Engineers Comments Regarding Surface Water Drainage

Application Reference:	BN/76/26/DOC	Reviewer Reference:	ADC/EXT2/113
Planning Officer:	Amber Willard	Date of Review:	07/09/2026
Site Name:	Land South Of Wandleys Lane Eastergate PO20 3SE		
Application Description:	Approval of details reserved by condition under BN/46/25/PL relating to conditions 4- Surface Water Drainage and 9- Maintenance & Management of Sustainable Drainage Scheme.		
Assessment Number:	2

Type D - 600 IC Non-entry
Inspection Chamber

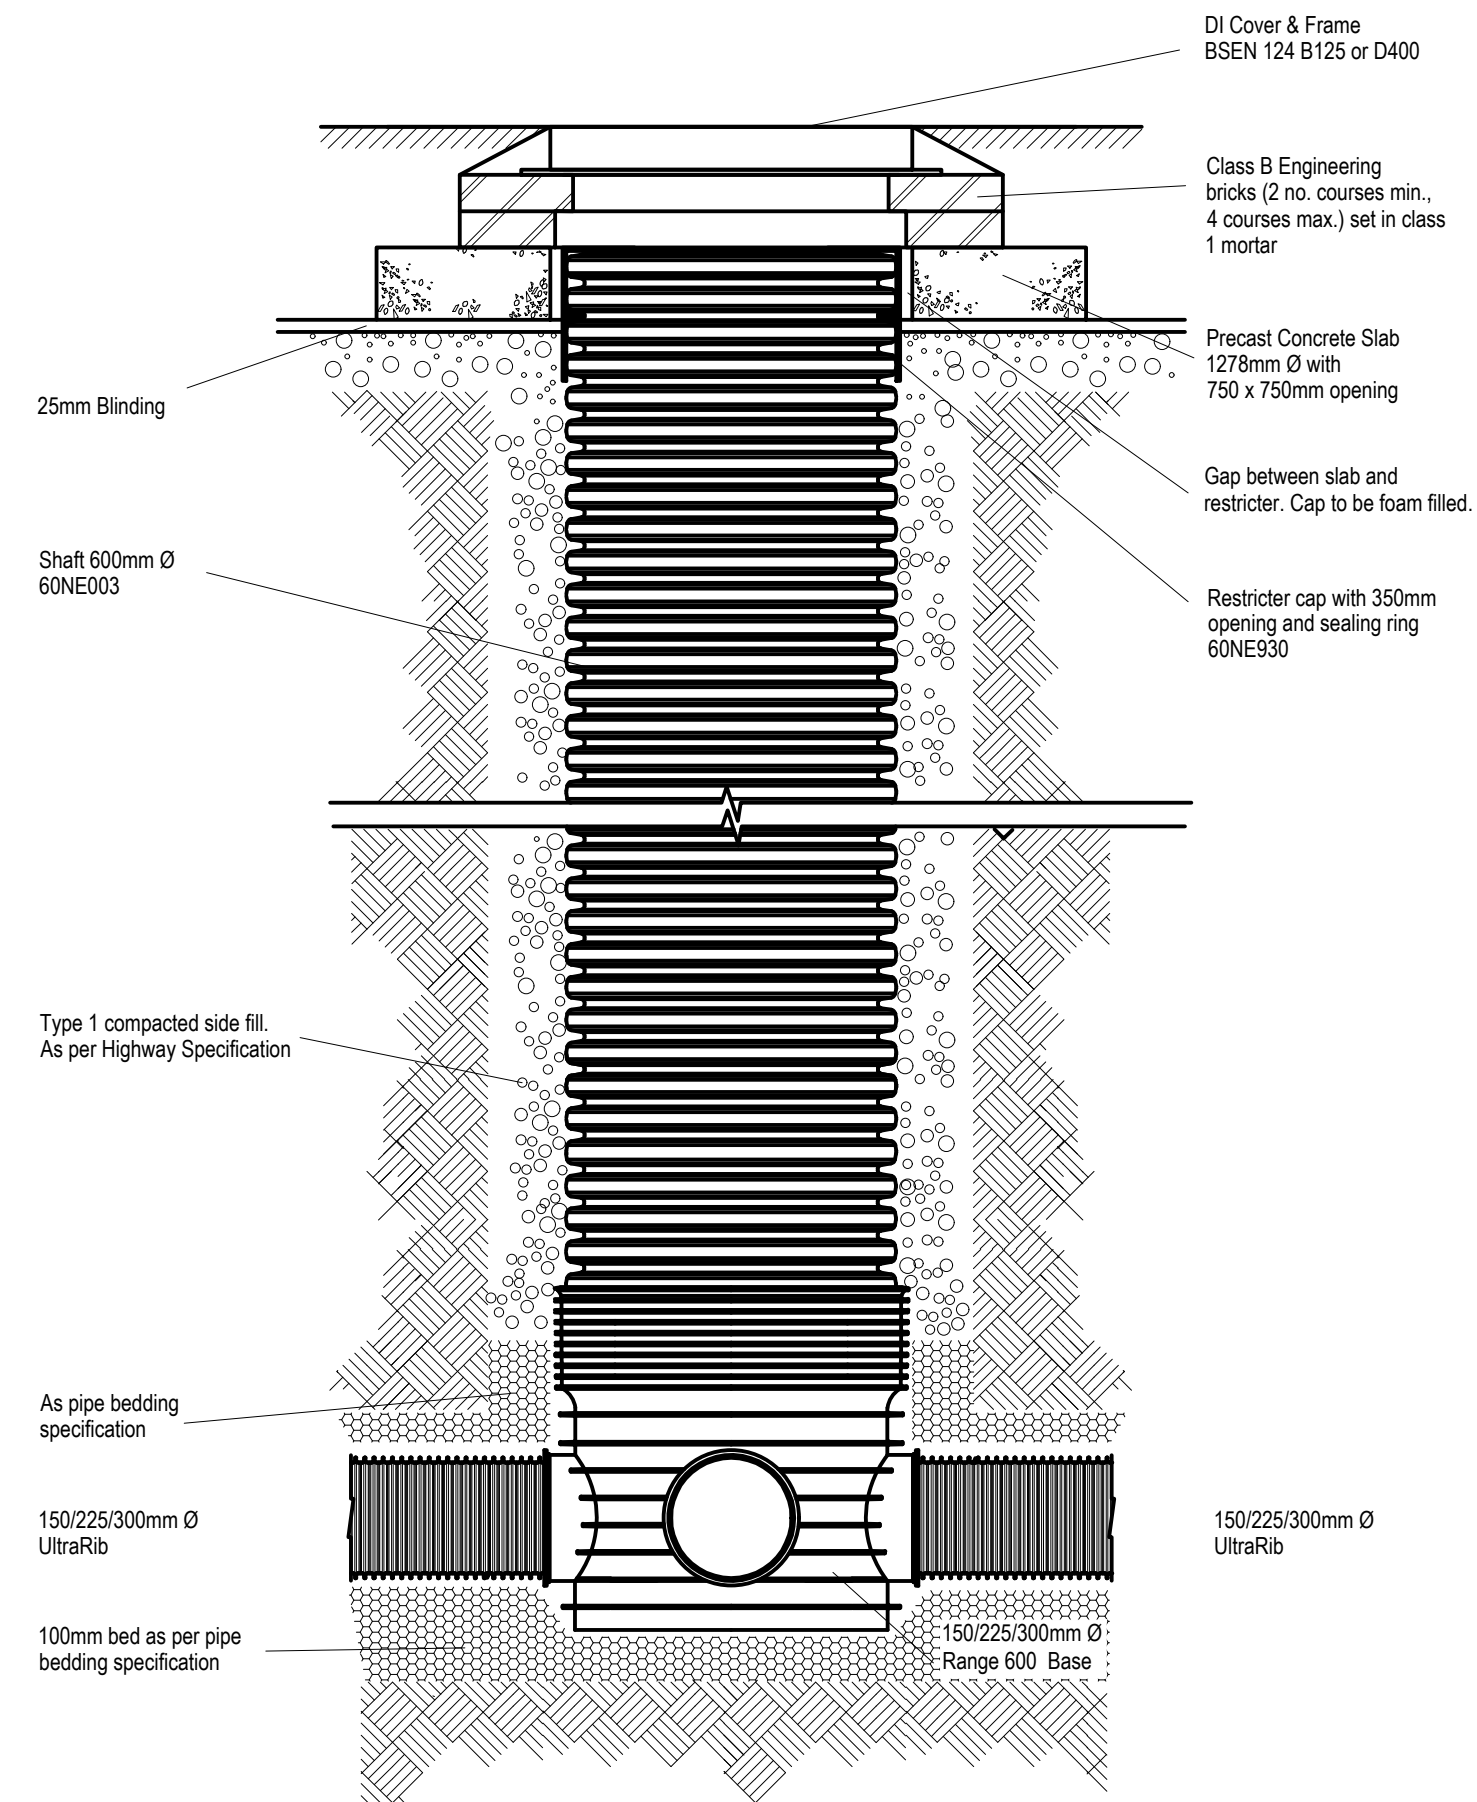
16.	Construction detail updated. Please refer to drg no. 476988-912_P03 – Construction Details-- Sheet 2.			Noted.	
17.	Our initial response was incorrect. There are several road gullies within the drainage designs.	Noted. Comment closed.

29.	Inspection chamber types have been added to the construction details. Please refer to drg no. 476988-912_P03 – Construction Details-- Sheet 2.	Noted. Comment closed.
